Consultation Response from: KC Environmental Health (Pollution & Noise Control)
2023/92278 - 507A Bradford Road, Batley, WF17 8LL
Formation of two additional floors and creation of six trade counter units within existing building and external alterations to existing brick clad portal framed industrial unit (within a Conservation Area)
**Responding Date:
09 November 2023**
**Responding Officer:
Mohammed Nasim**
**Responding Ref:
WK202332652**
Comments
Noise

Block Plan 1: 200

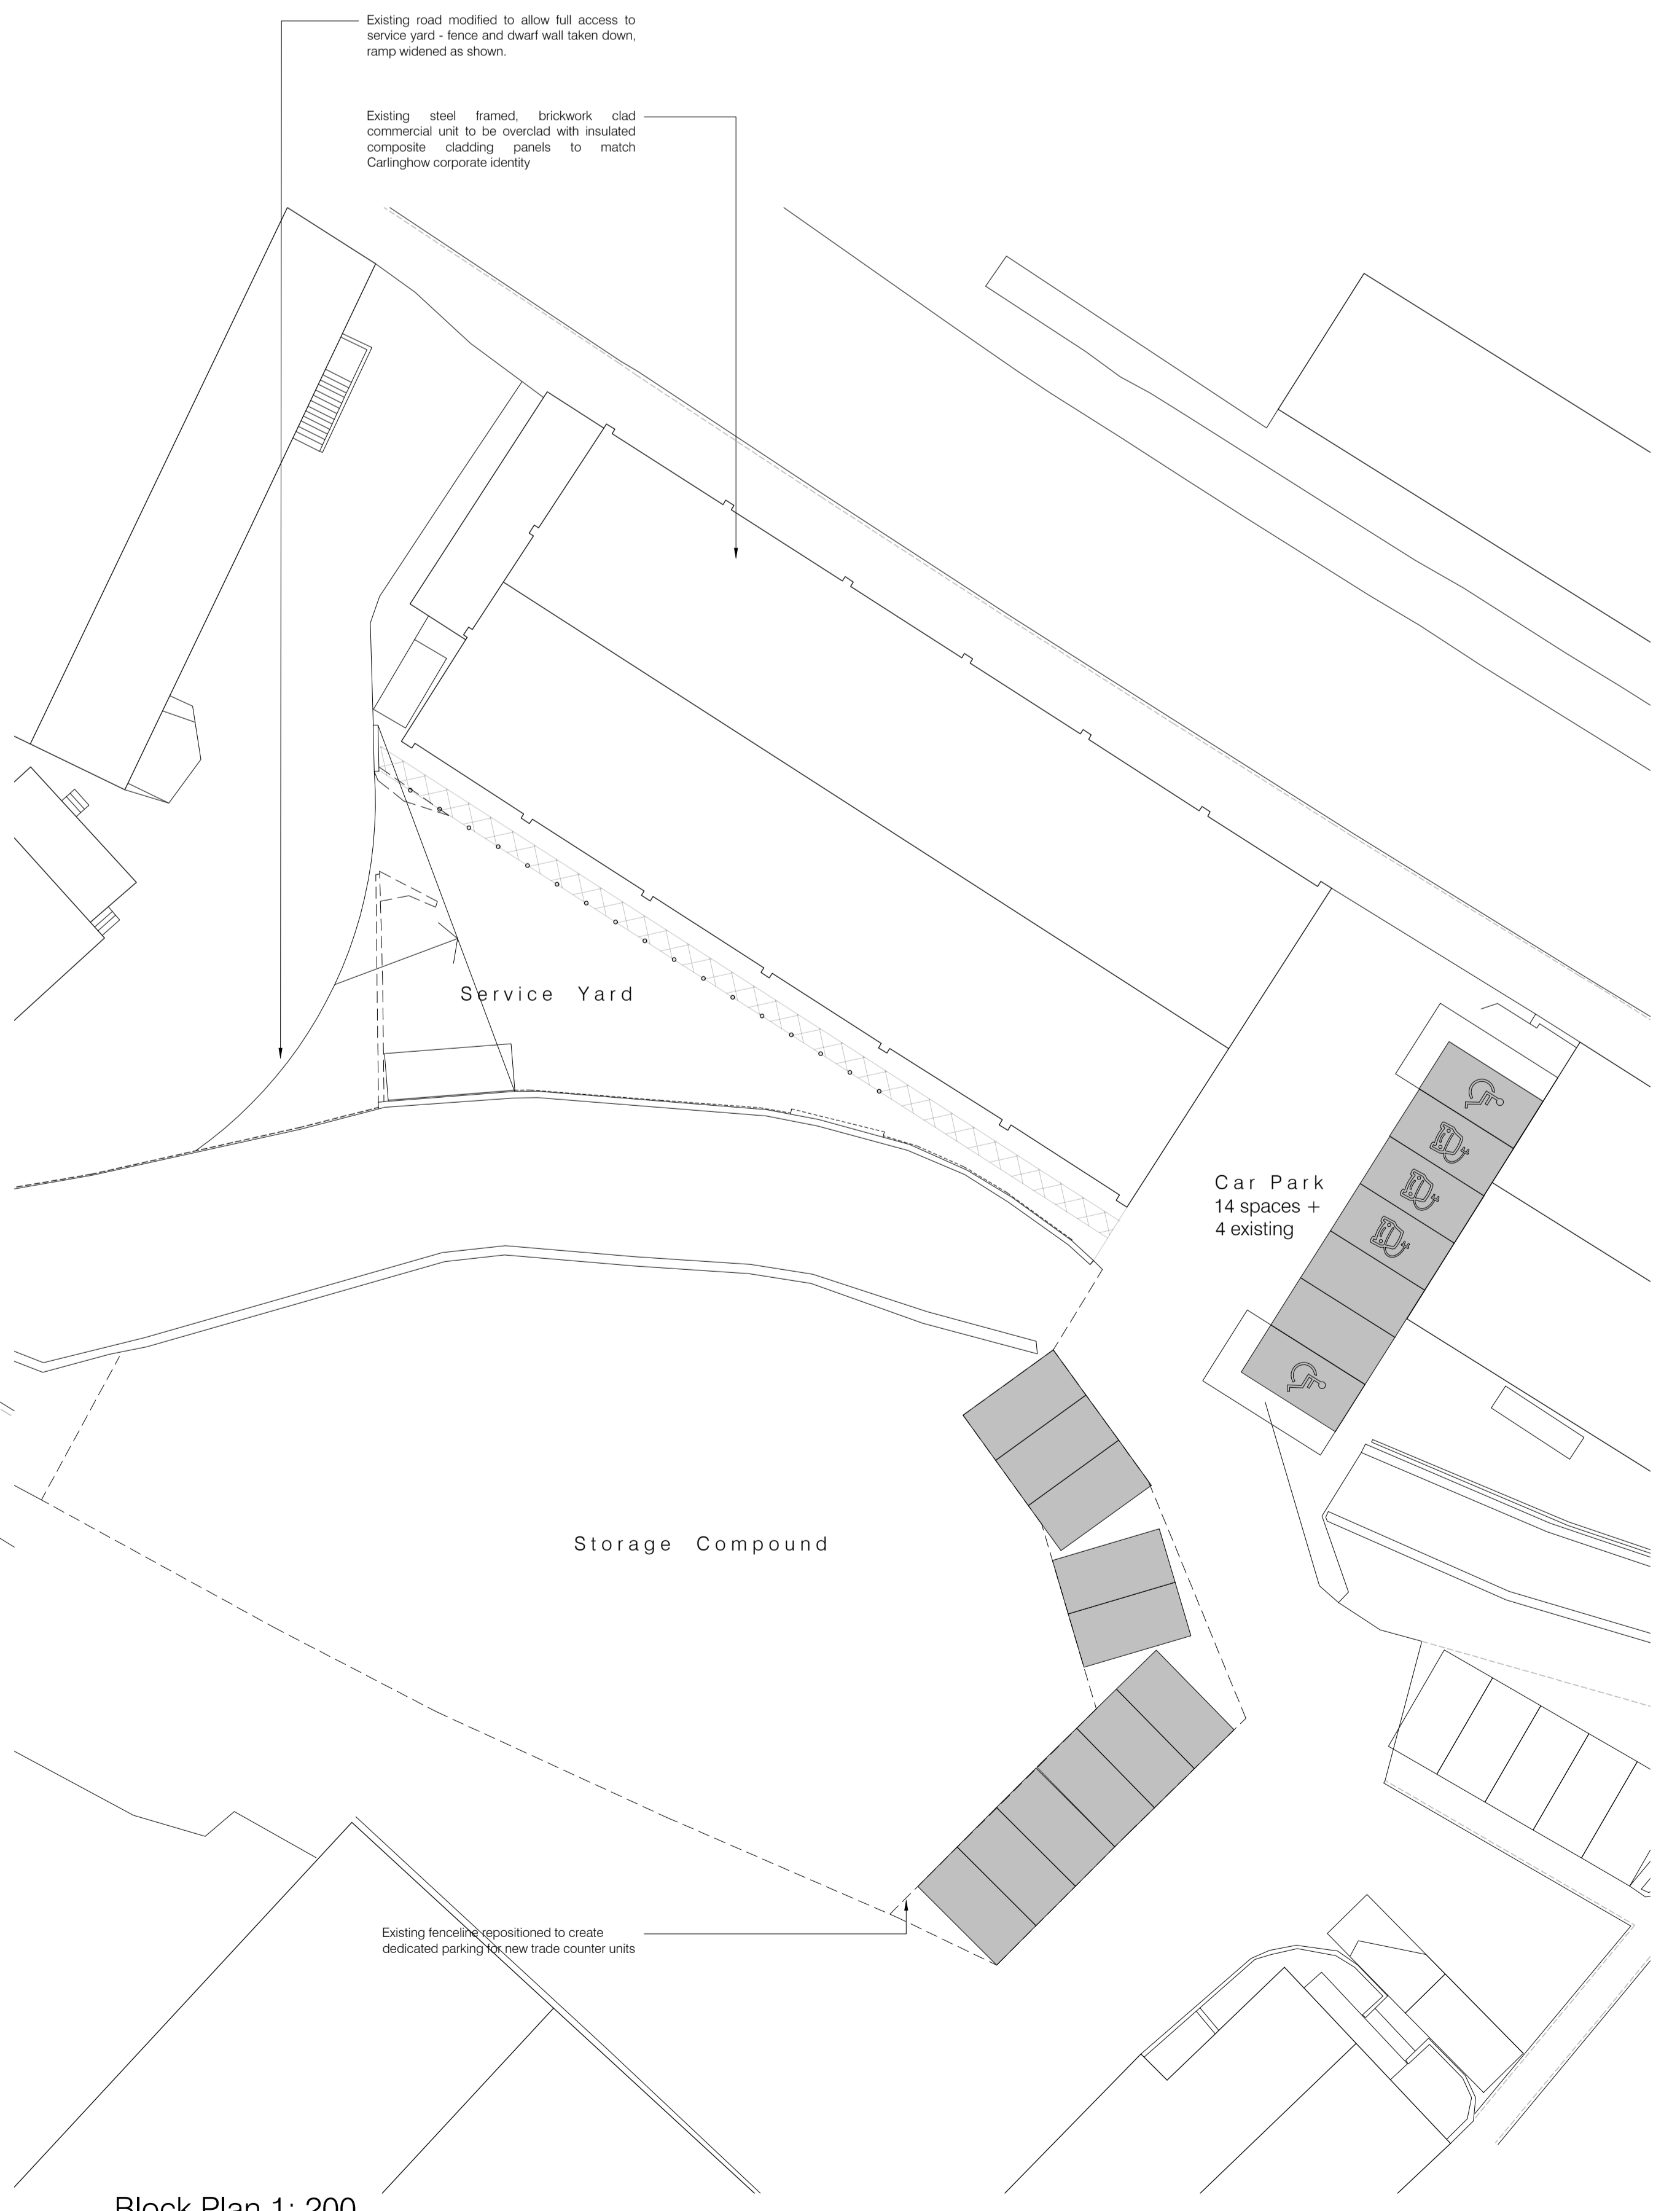
This site has been identified on our mapping system as potentially contaminated land due to its previous use as a mill and chemical works (our map ref 67/5). The submitted proposed external alterations plan from jgd dated June 2022 Ref 20832(2) shows some additional car parking which is assumed to be on hard standing. As there is no sensitive end use, a condition for encountering unexpected land contamination is recommended.

CLC6 Reporting of Unexpected Contamination - Condition

In the event that contamination, or the presence of coal not previously identified by the developer prior to the grant of this planning permission is encountered during the development, all groundworks in the affected area (except for site investigation works) shall

cease immediately and the Local Planning Authority shall be notified in writing within 2 working days. Groundworks in the affected area shall not recommence until either (a) a Remediation Strategy by a suitably competent person has been submitted to and approved in writing by the Local Planning Authority or (b) the Local Planning Authority has confirmed in writing that remediation measures are not required. The Remediation Strategy shall include a timetable for the implementation and completion of the approved remediation measures. Thereafter remediation of the site shall be carried out and completed in accordance with the approved Remediation Strategy.
